ASSESSMENT REPORT

Mixed Use Development – 1 Lawson Square, Redfern SSD 5249 MOD 5

The application has been lodged by Ethos Urban on behalf of Lawson Square Pty Ltd pursuant to section 4.55(1A) of the *Environmental Planning and Assessment Act 1979* (EP&A Act). It seeks approval to add roof top terraces to the eastern tower to be used in association with two approved top floor apartments.

DRAWING:
ELEVATIONS SHEET 1
NORTH ELEVATION
DRAWING No:
S96 - 1301
ISSUE:
M

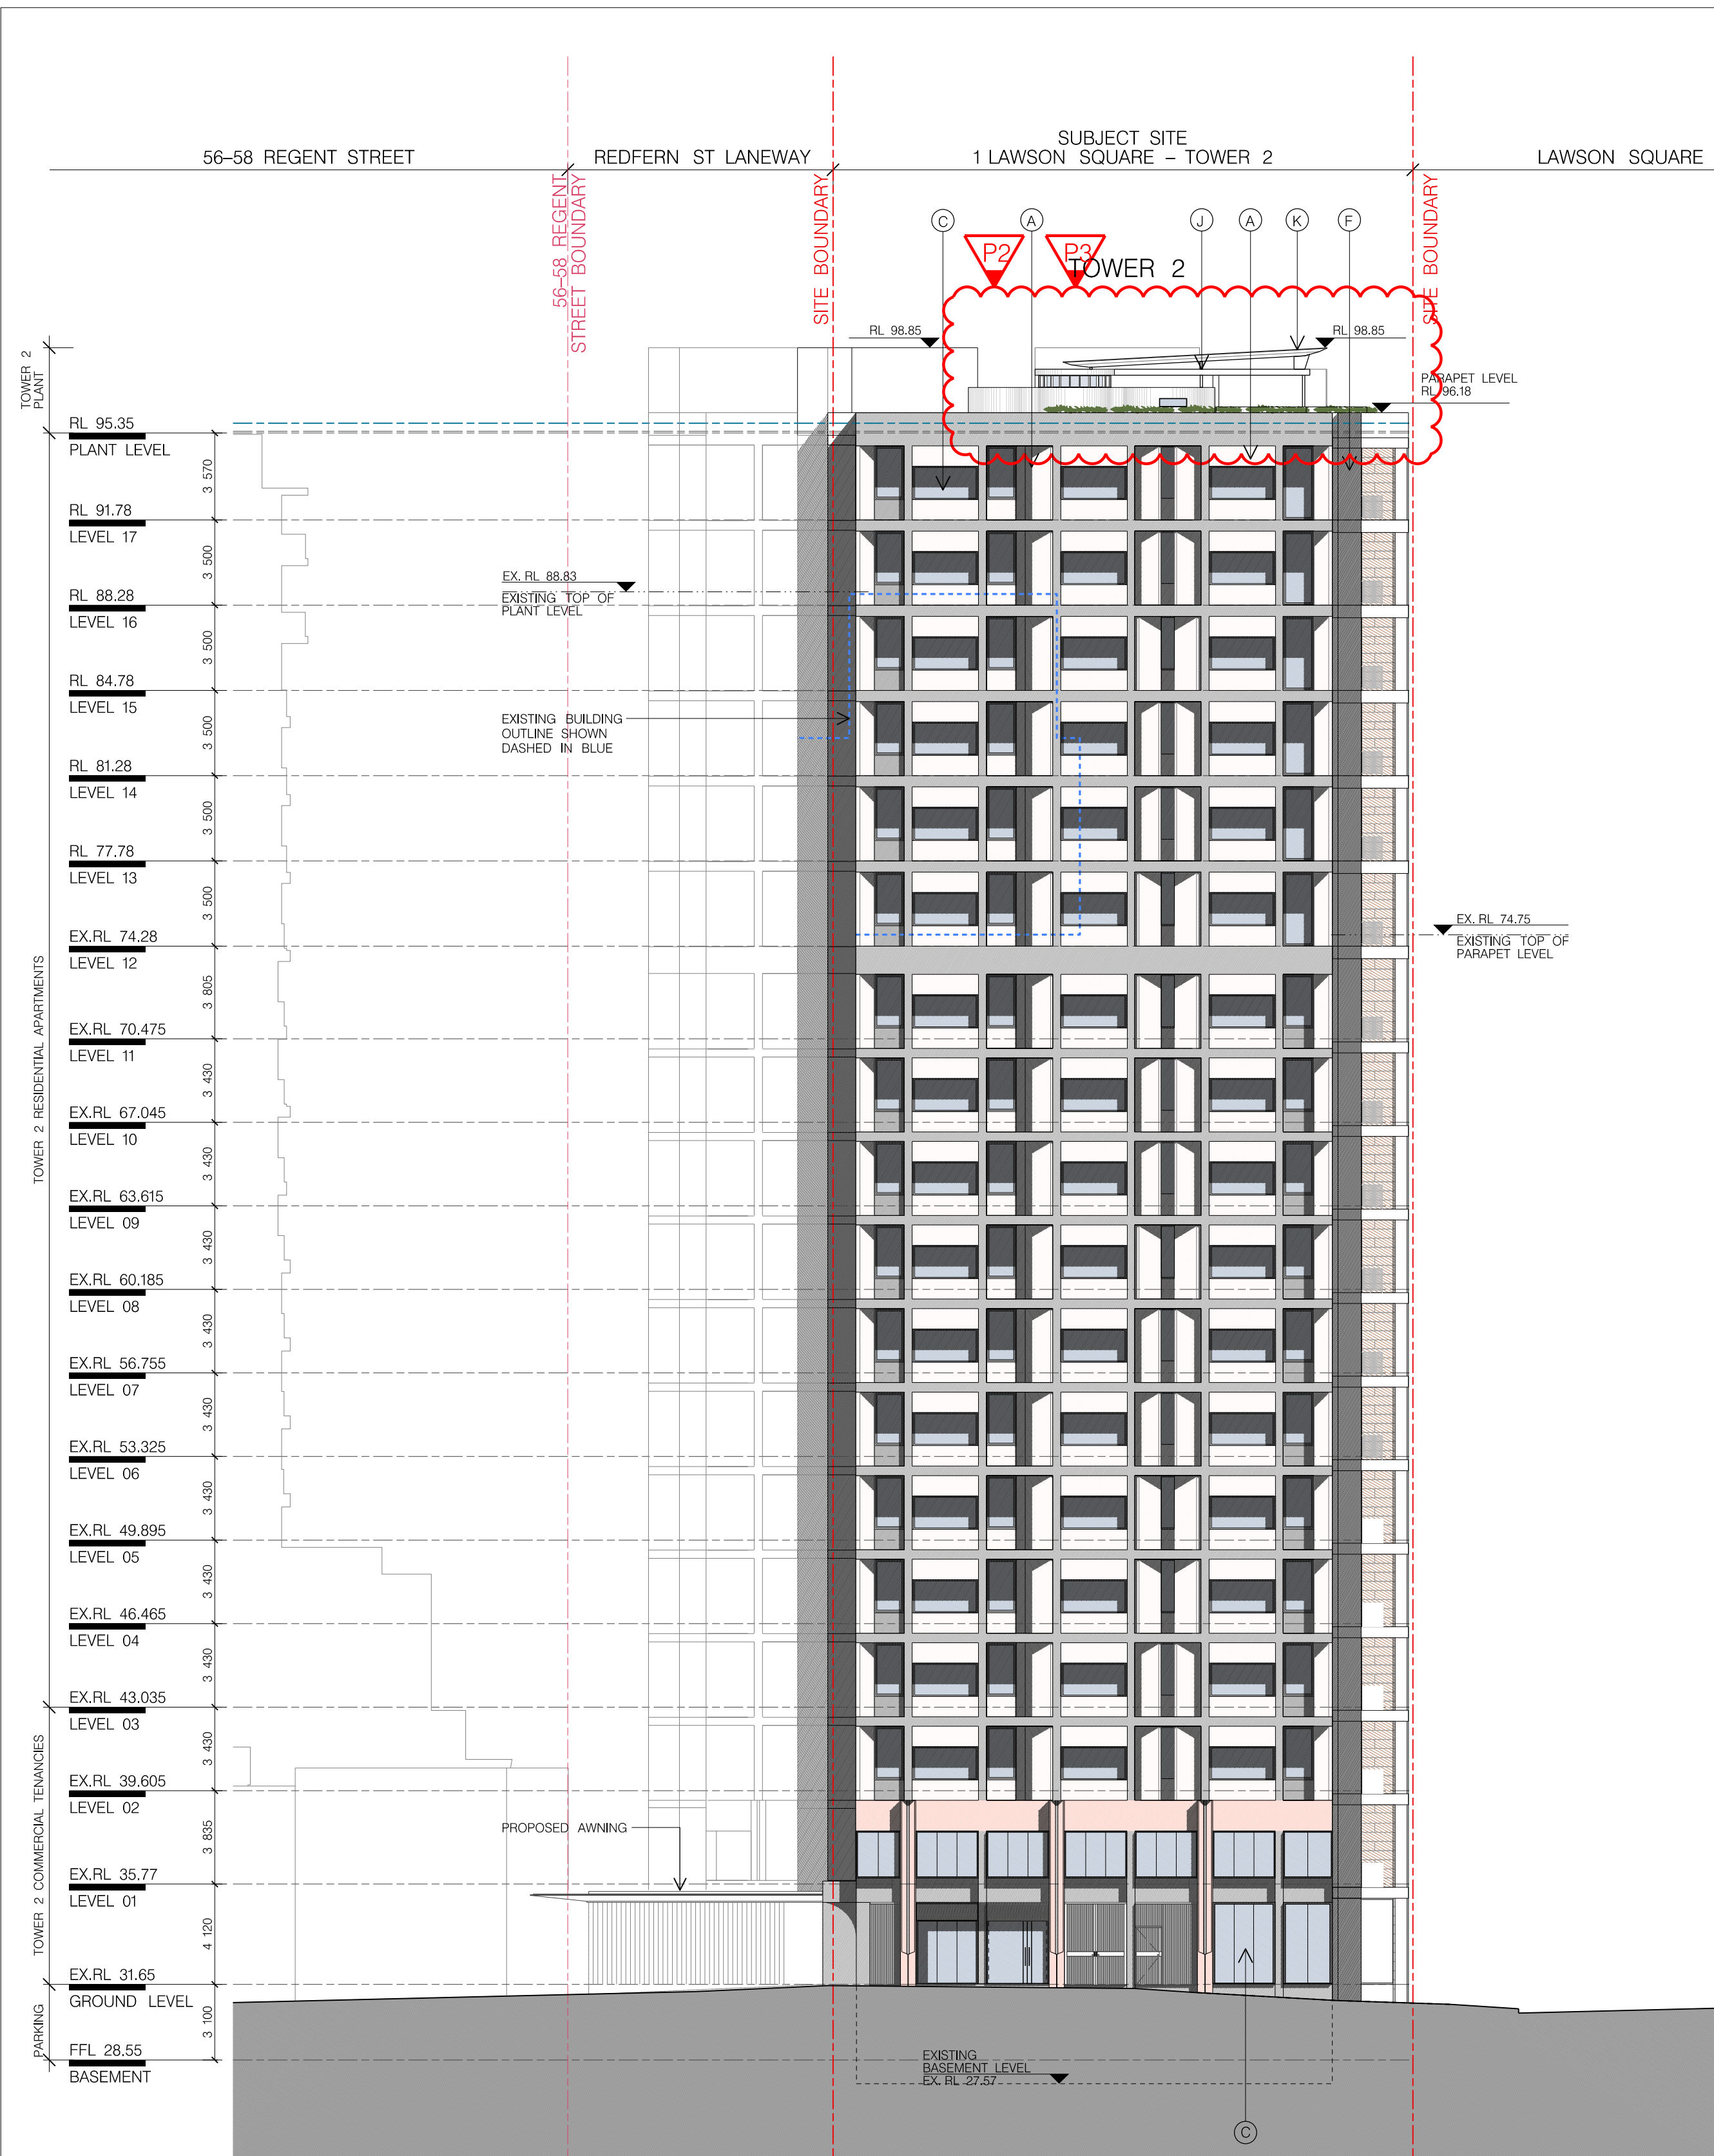
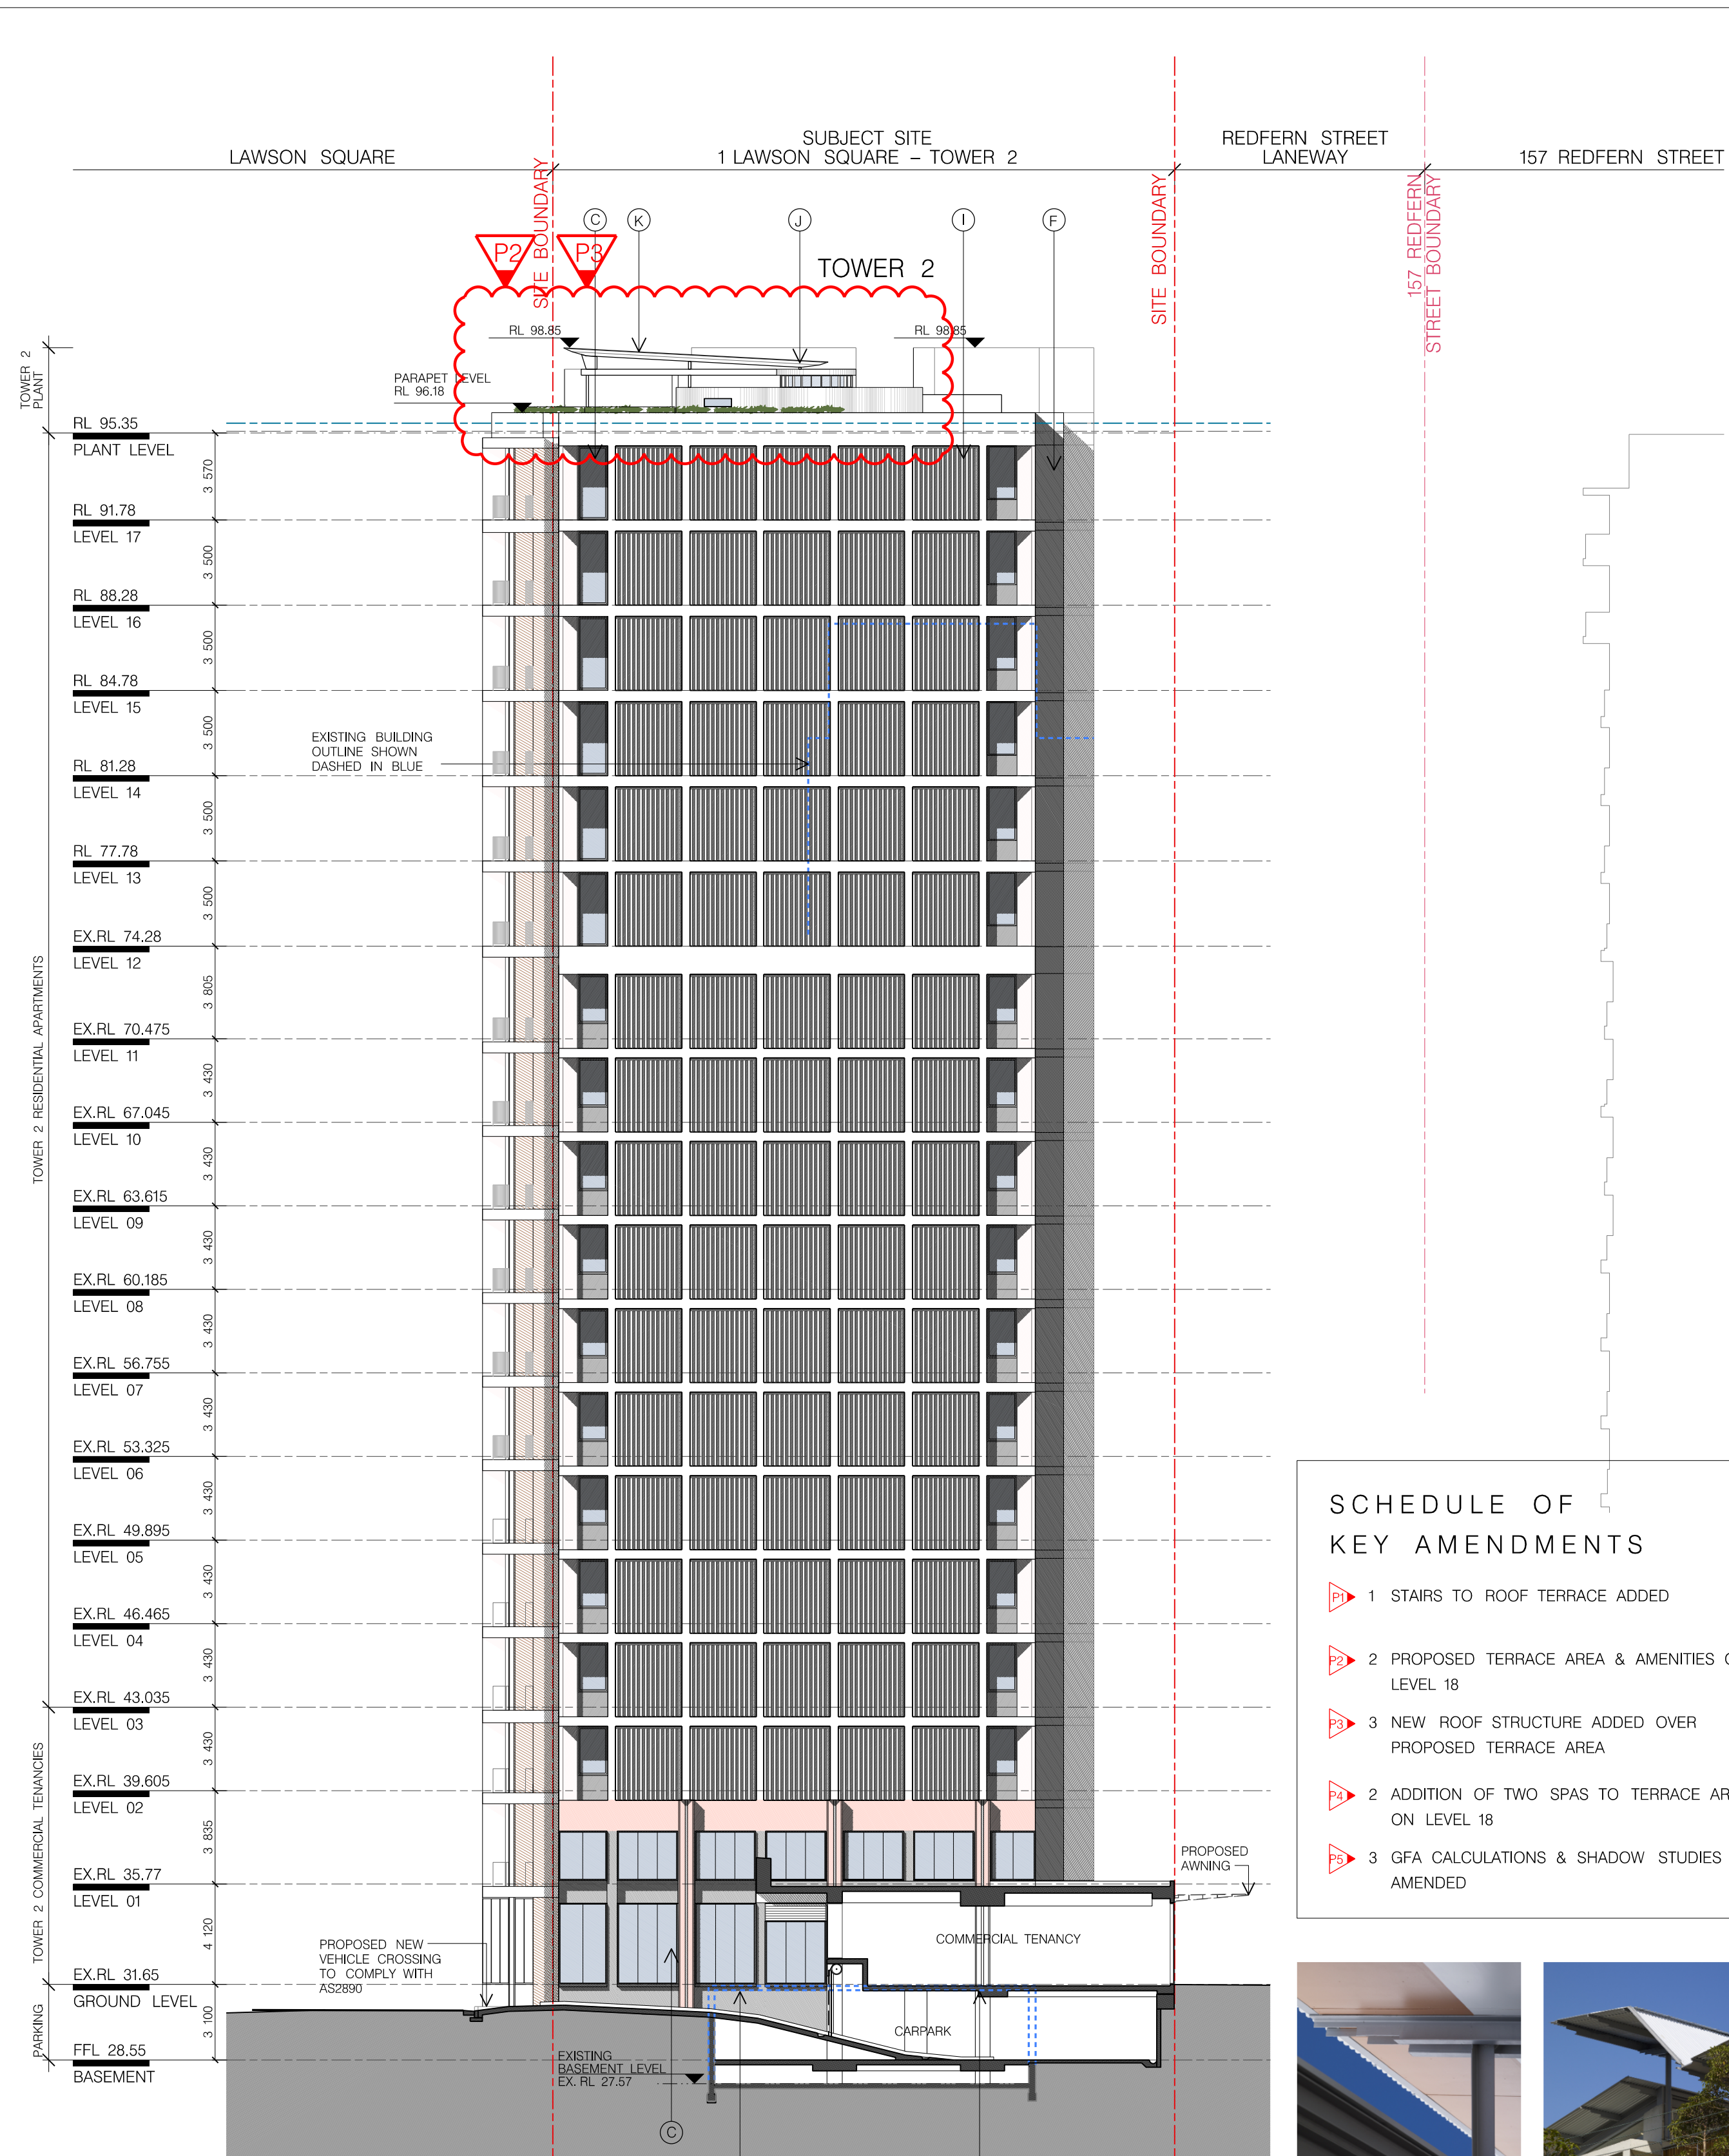
Council advised it would not be making a formal submission on the application however it recommended investigating whether a reduced roof form would reduce overshadowing impacts.

Visual Impacts	• The proposed changes to the roof level would result in a minor increase to the height and scale of the building when viewed from a distance. • The roof canopy would be the most visible aspect. However, it would be a lightweight structure, with a maximum height consistent with the plant rooms, generally open in appearance and setback on average 2.4 m from the building edge. • Apart from the roof canopy, the curvilinear walls around the bathrooms and spas would be visible from some vantage points, predominantly from the east. However the proposed walls would also be setback from the building edge, would be lower in height than the roof canopy and plant rooms and would be constructed of materials to complement the existing building. • The Department considers that as the proposed structures would be set back from the building edge they would not be dominant visual elements, would not detract from the design excellence qualities of the	No additional comments or amendments necessary

approved building, and would not have any impact for the overall character of the area. - The proposed changes would also improve the architectural quality of the roof level, obscuring views of the approved plantrooms with new curvilinear walls, an architectural roof form and plantings. - The Department therefore considers the proposed structures would make a positive contribution to appearance of the building.	
<i>Shadowing</i>	- The Applicant submitted shadow diagrams to demonstrate the shadowing effects of the proposed modification. - Shadows cast from the proposed roof terrace structures would fall predominantly on to the southern part of the roof of the approved development and for the majority of the day would not affect any adjoining development. - In the mid-late afternoon at midwinter the proposal would result in a nominal amount of additional shadows cast to the west of the site. - Council recommended investigating whether a reduced room form would reduce or eliminate the increased overshadowing effects. - The Department has considered the shadows and notes the area of additional shadow would not be perceptible in the context of shadowing from the approved building and would predominantly be within areas already in shadow from other surrounding buildings. - The shadowing impacts are therefore considered to be negligible and of no consequence, and no amendments to the roof form are required.	No additional comments or amendments necessary
